From: Charlotte Burrows on behalf of Planning.Responses
Sent: 24 June 2013 09:43
To: Planning Scanning; Amanda Scholes
Subject: FW: Planning Consultation on LY/13/13/DOC

APPLICATION **LY/13/13/DOC**
NO:

Registered: 06-JUN-13
Site Address: Barn at Calceto Lyminster BN17 7QL

Description of Works: Application for approval of details reserved by conditions 3, 4 and 7 of LY/1/13 - Landscaping, drainage & bat owl habitat

Client	South by East Developments
Drawing Title	Drainage Layout

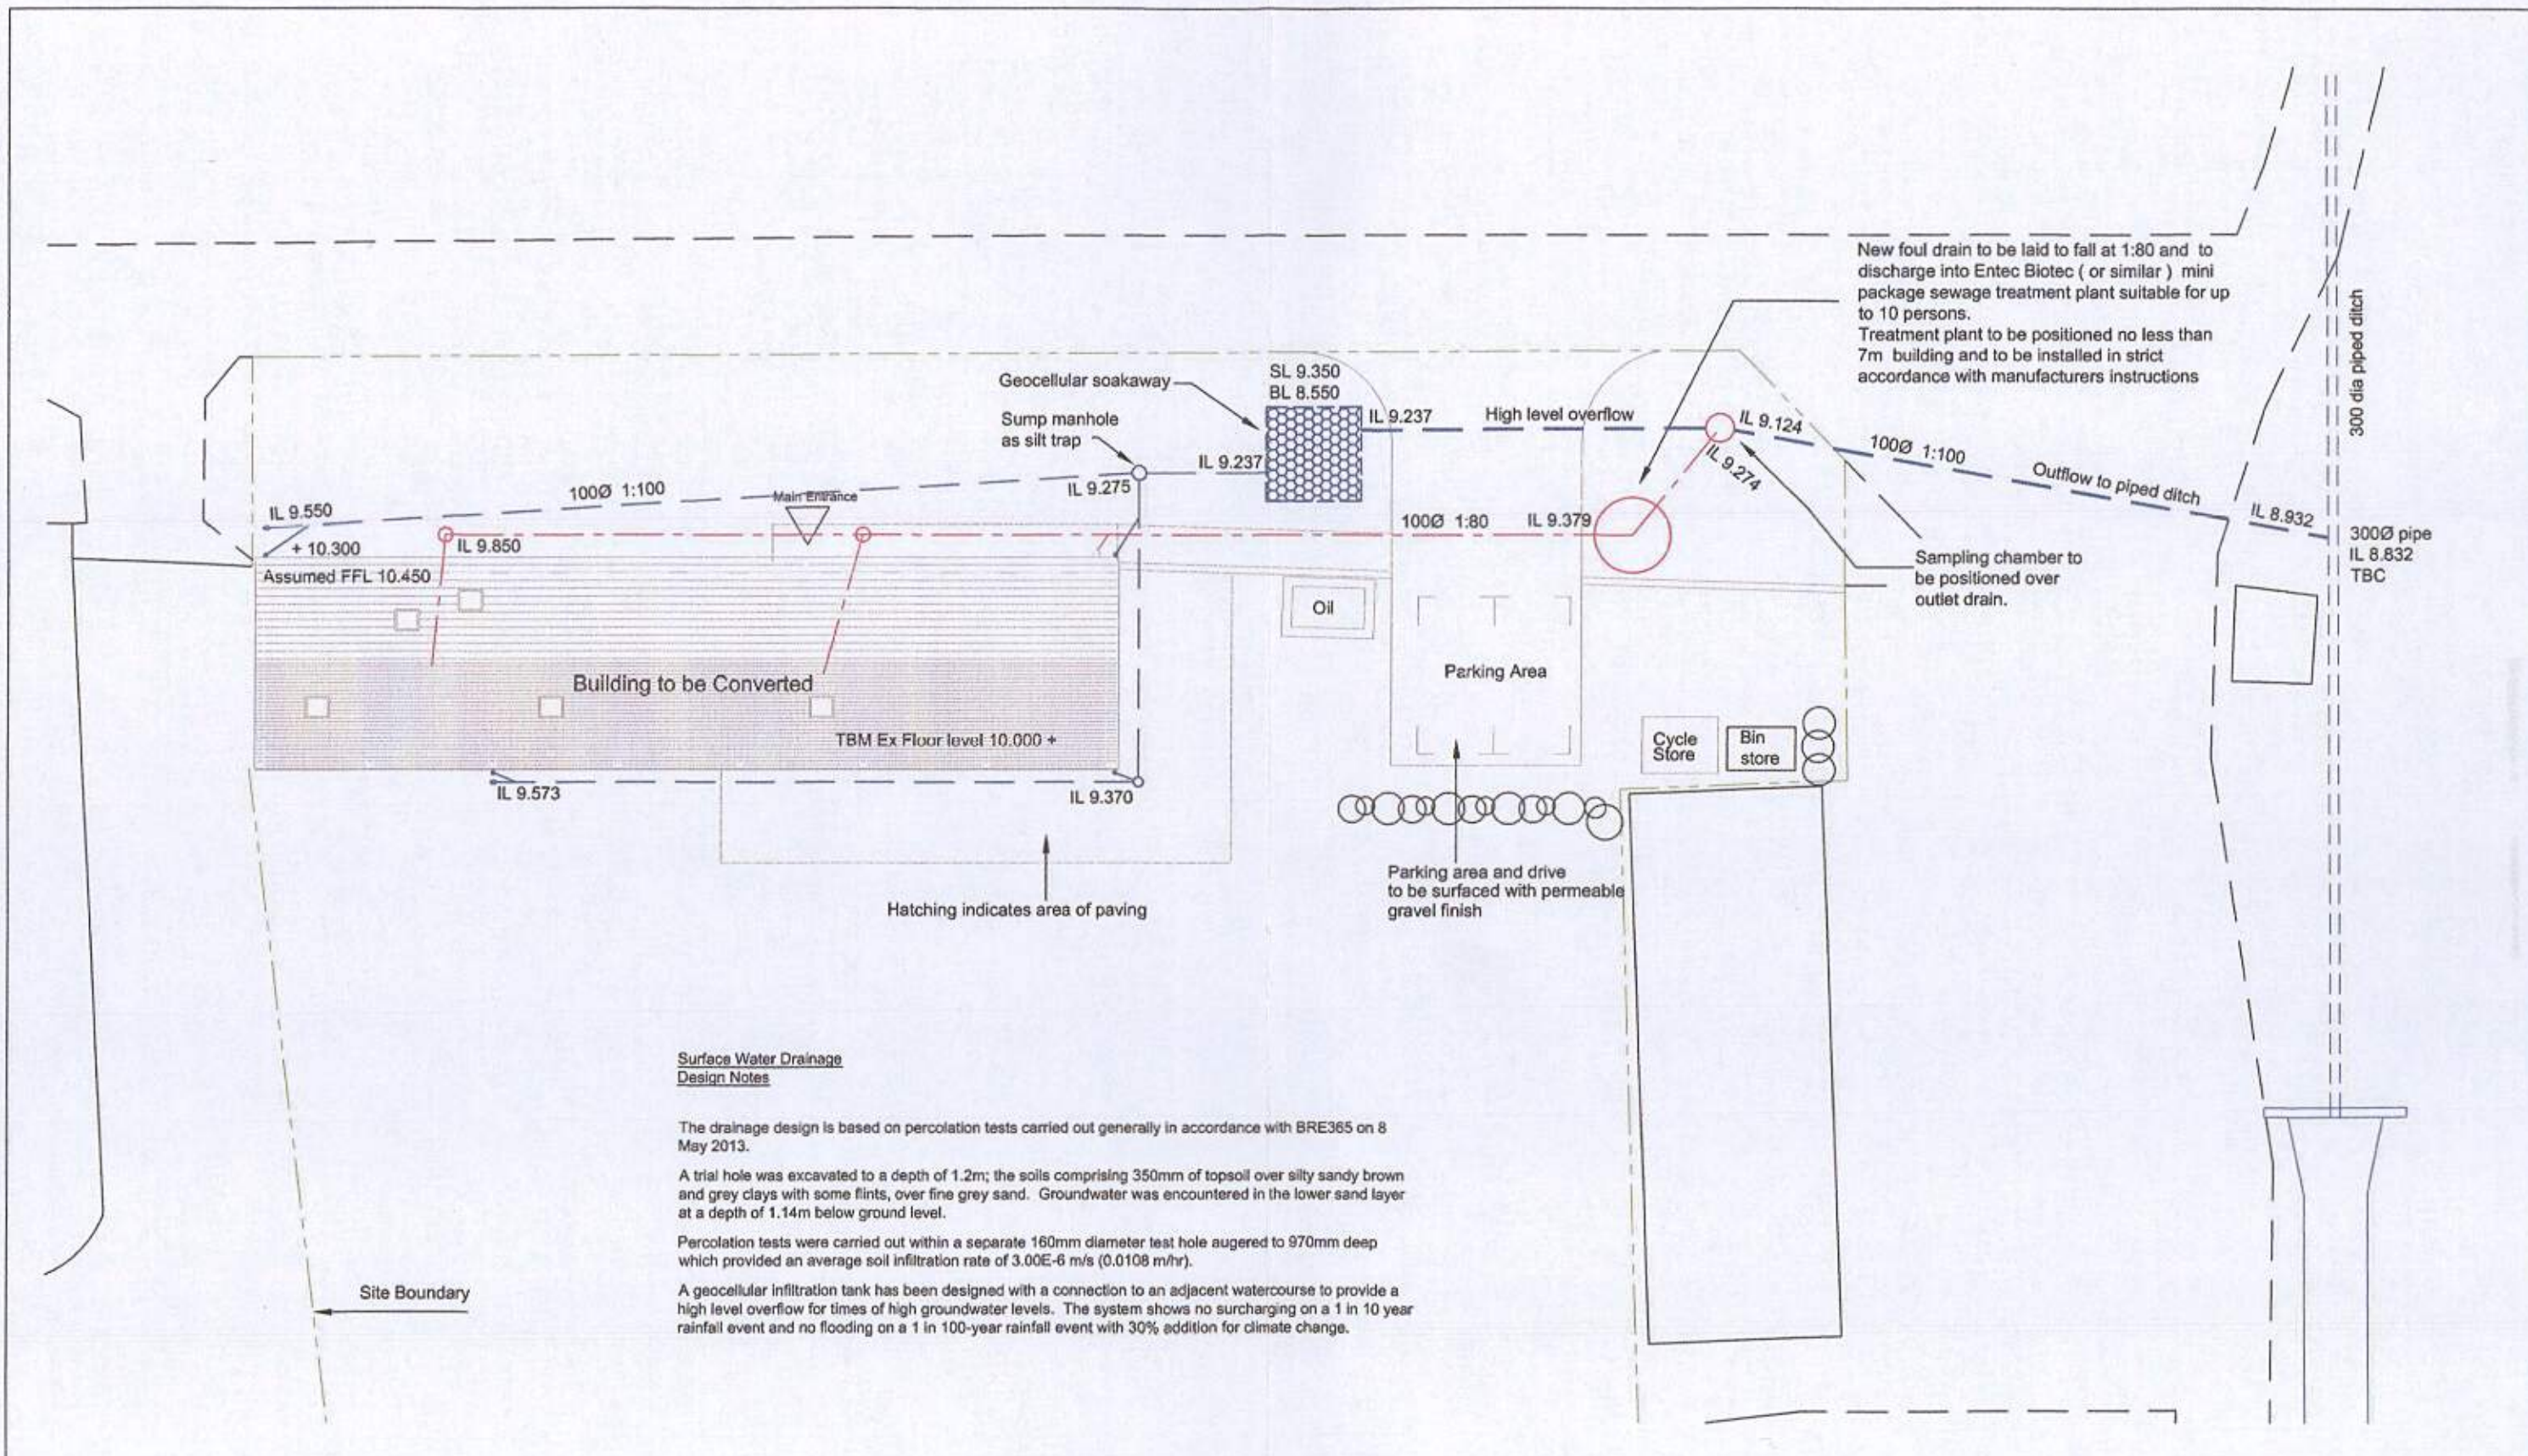
The drainage condition cannot be discharged at this time since there is insufficient information to access the application. The additional information required is as follows:

1. Data/calculations to prove the percolation rate.
2. Calculations for the soakaway design (1 in 10 year storm event and the 1 in 100 year storm event including 30% allowance for climate change)

Due to the fact that the percolation testing and groundwater monitoring were carried out in May 2013 (ie. just outside the recognised winter period), an appropriate safety factor should be applied to the design to allow for potentially poorer percolation rates and higher groundwater levels that are experienced during the winter months. Please note that the overflow should only operate in events beyond the 1 in 100 year storm.
